Objection to Planning Application: [2026/62/90484/E]

Address of Proposal: [143 Church Lane, Gomersal, BD19 4QN]

Proposed Development: Change of use from C3 (Residential) to C2 (Residential Institution up to 4 individuals aged 7-18) and extension above existing garage.

## Proposed Plans & Elevations

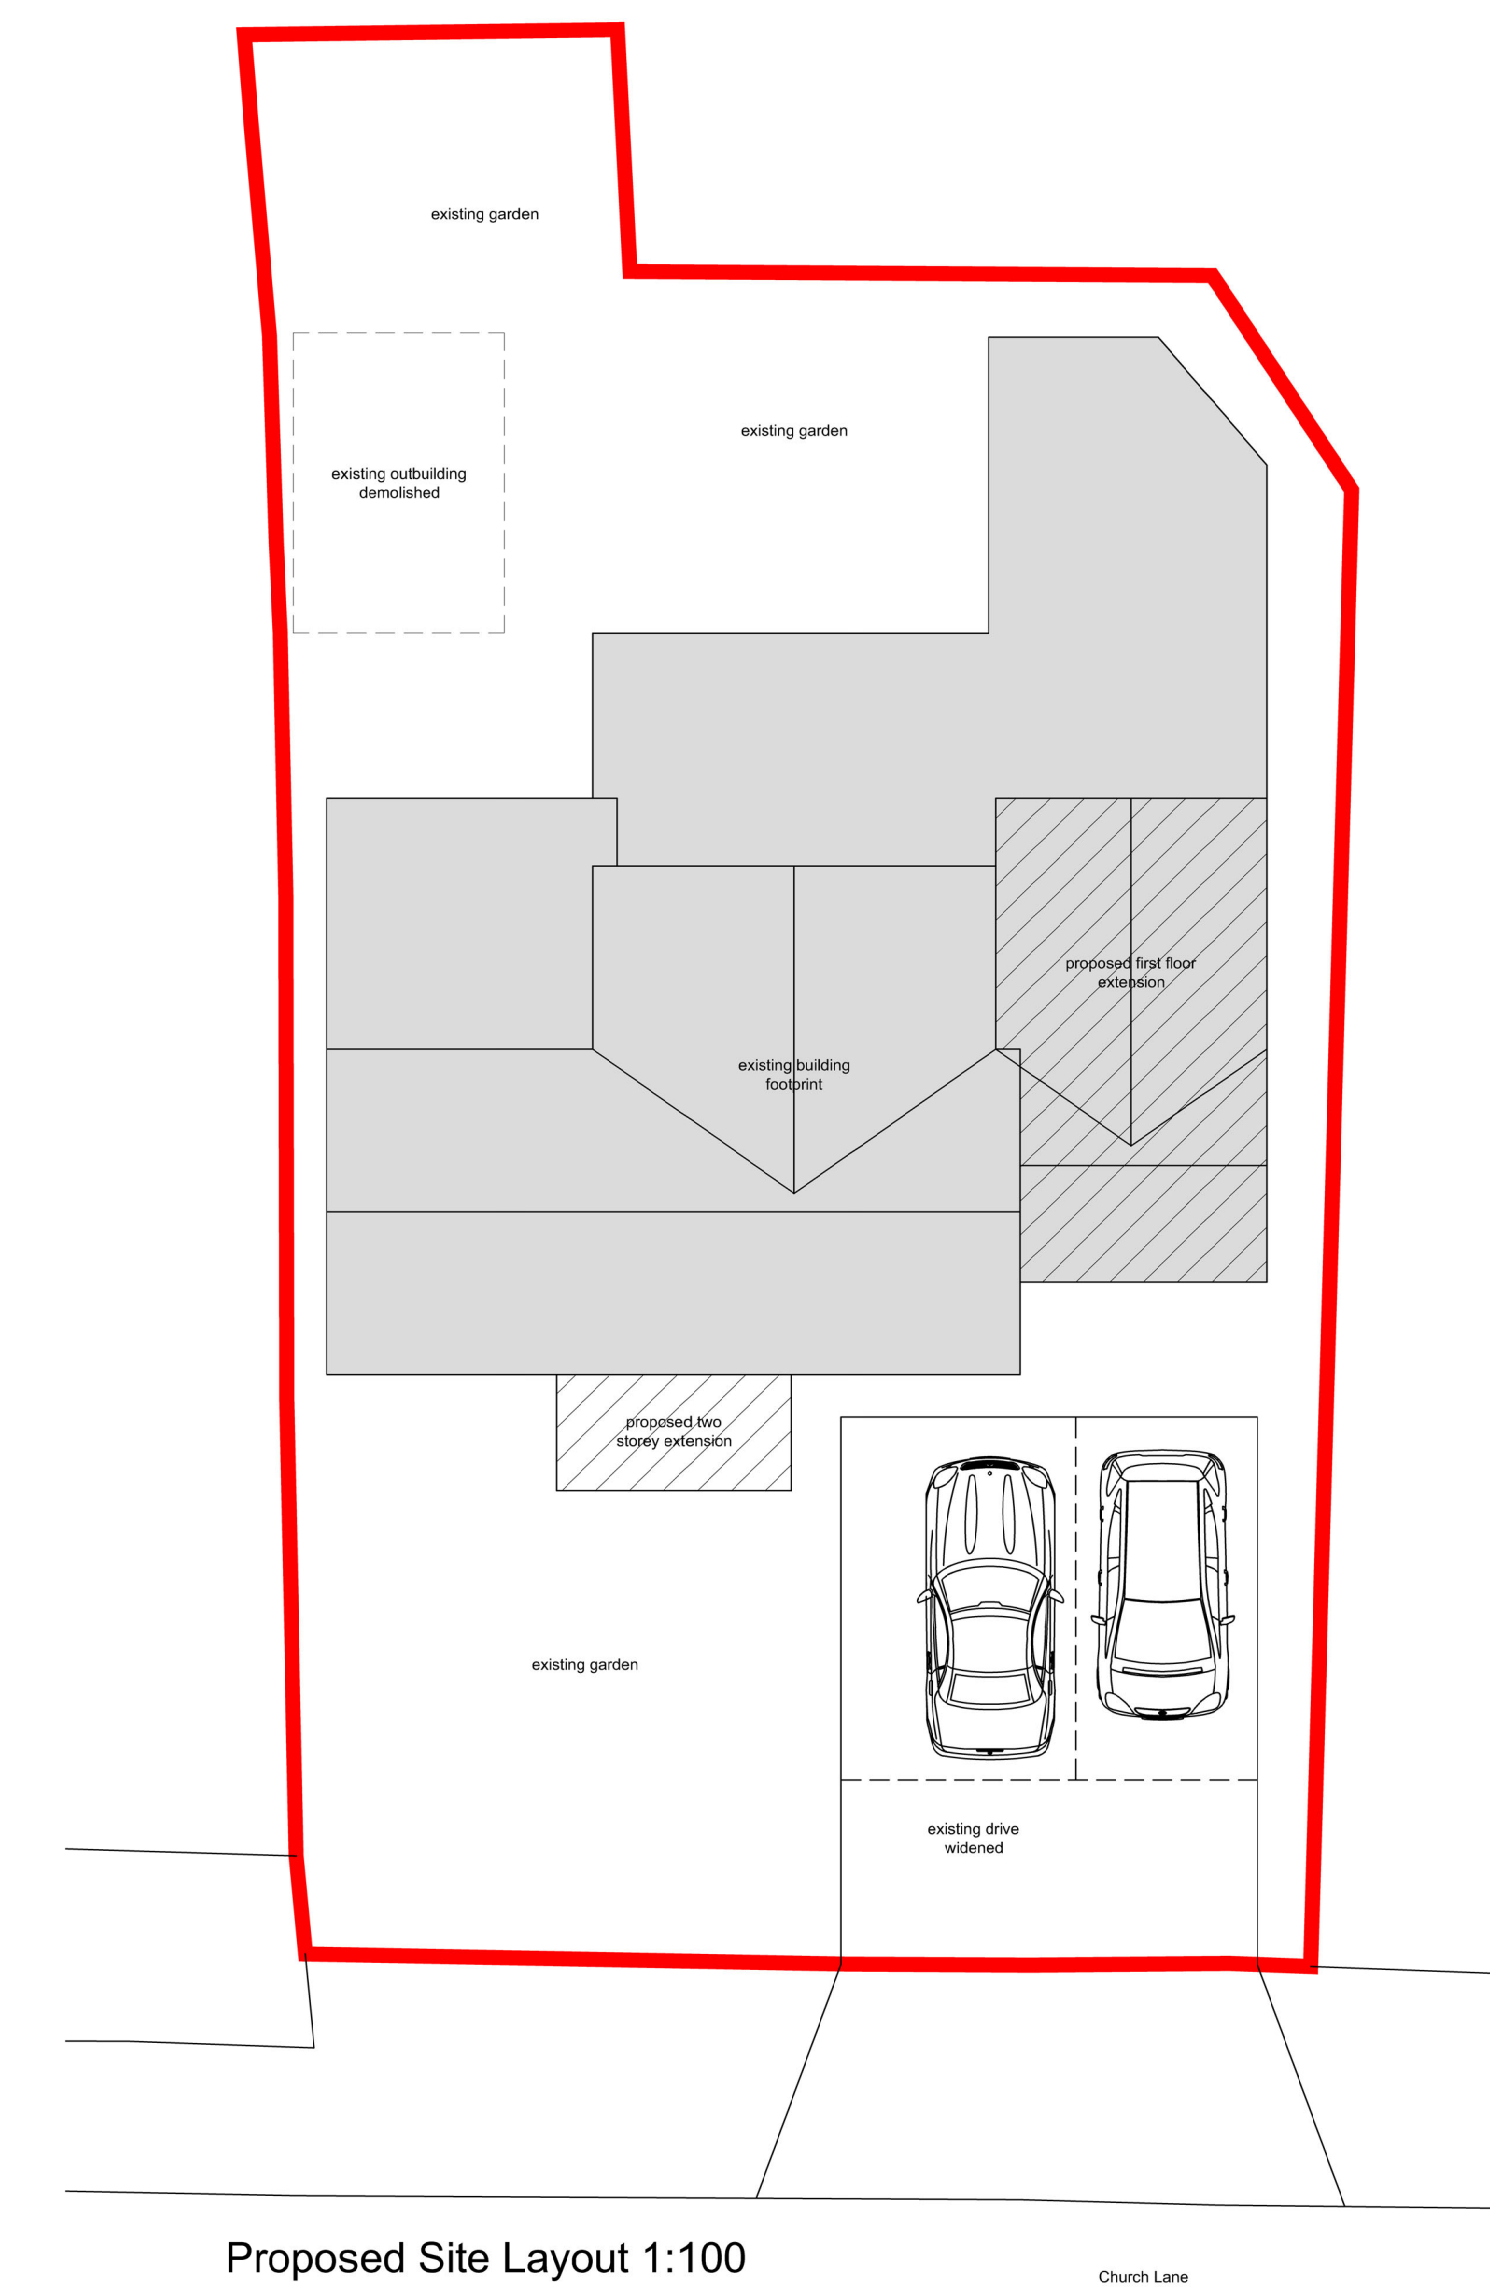
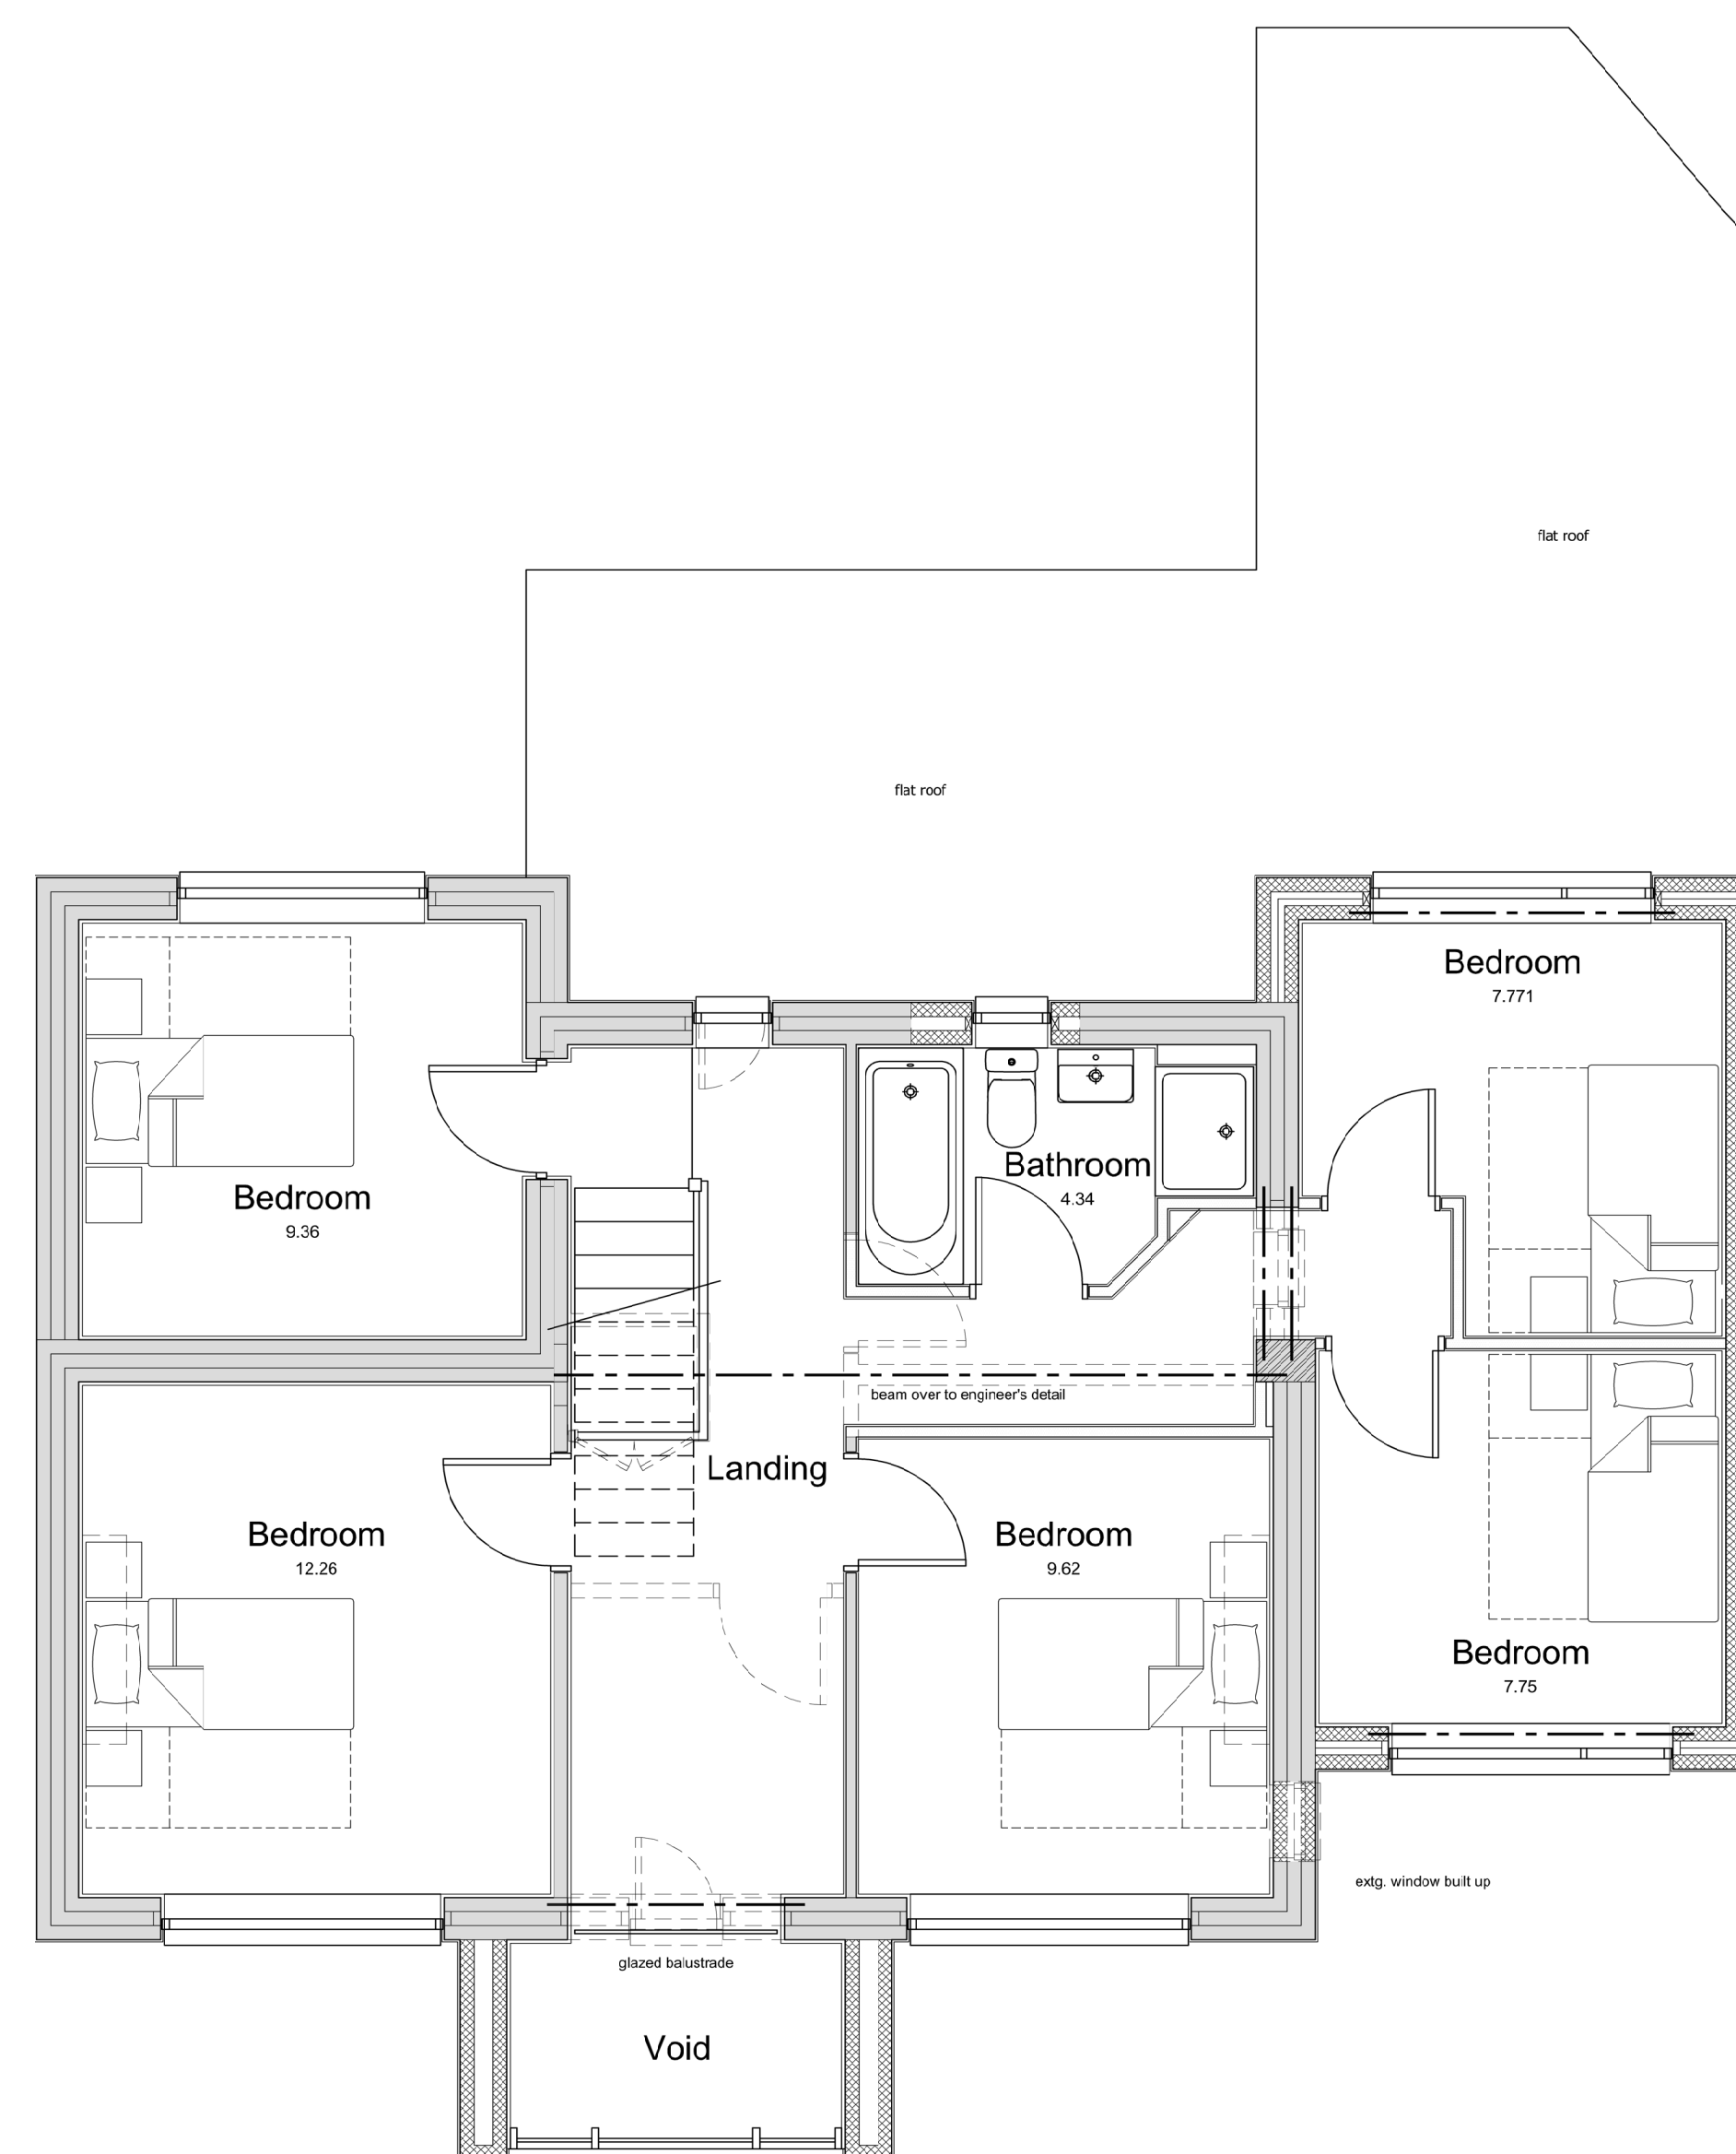
- Ideally the property should provide safe, well-maintained outdoor spaces to support children's physical/mental health and wellbeing offering areas for active play. From looking at the plans submitted, outdoor space is extremely limited.

- If the planning for building over the existing garage was allowed it would present significant privacy issues for the nearby existing houses and indeed any children placed at 143 Church Lane.

- Two of the adjacent gardens are much lower than 143 Church Lane meaning the existing garage is already a significant height. Building a second-floor extension will seriously impact on natural daylight and privacy. Plans show an overdevelopment of the site hence little outdoor space. A site visit would illustrate this much better rather than just looking at plans.
